Item No. **Report of the Interim Director of Planning, Regeneration & Public Realm**

Address 60 LONG LANE ICKENHAM MIDDLESEX

Development: Demolition of existing dwelling and erection of two storey detached building with habitable roof space to provide 8 x 2-bed flats and 1 studio flat with associated amenity space and parking.

LBH Ref Nos: **70282/APP/2022/1143**

GROUND FLOOR

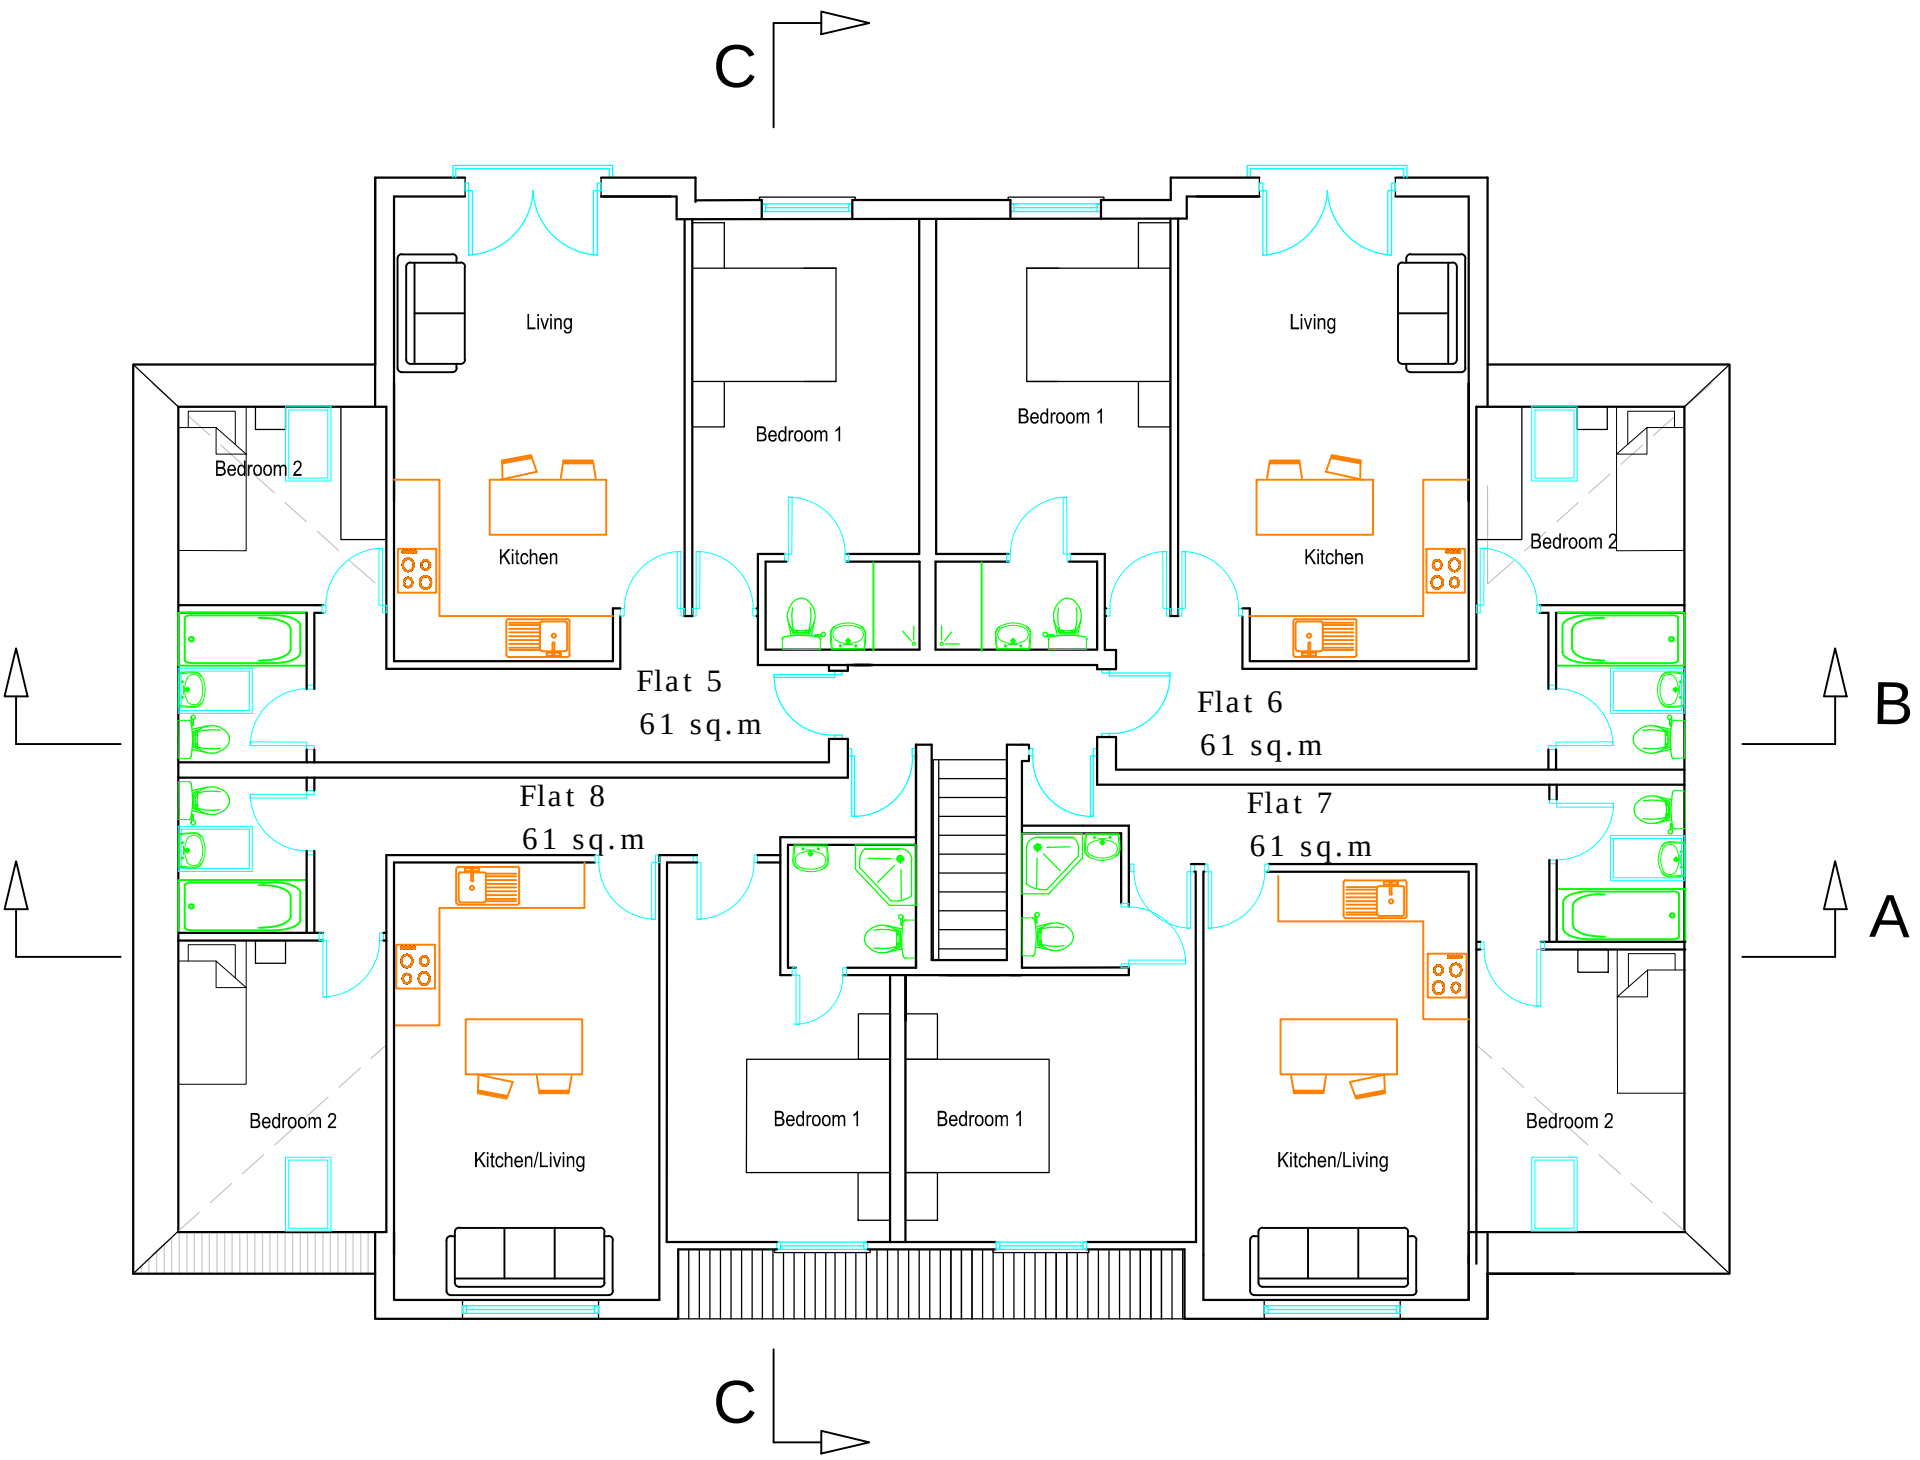
The proposed development, by virtue of the substandard internal floor area of the single bedrooms, would result in substandard forms of residential accommodation to the detriment of future occupants of Flats 1, 2, 5 and 6. The proposal would therefore result in substandard forms of residential accommodation to the detriment of the amenity of future occupants of the proposed development, contrary to Policy DMHB 16 of the Hillingdon Local Plan: Part Two - Development Management Policies (2020), Policy D6 of the London Plan (2021) and the National Planning Policy Framework (2021).
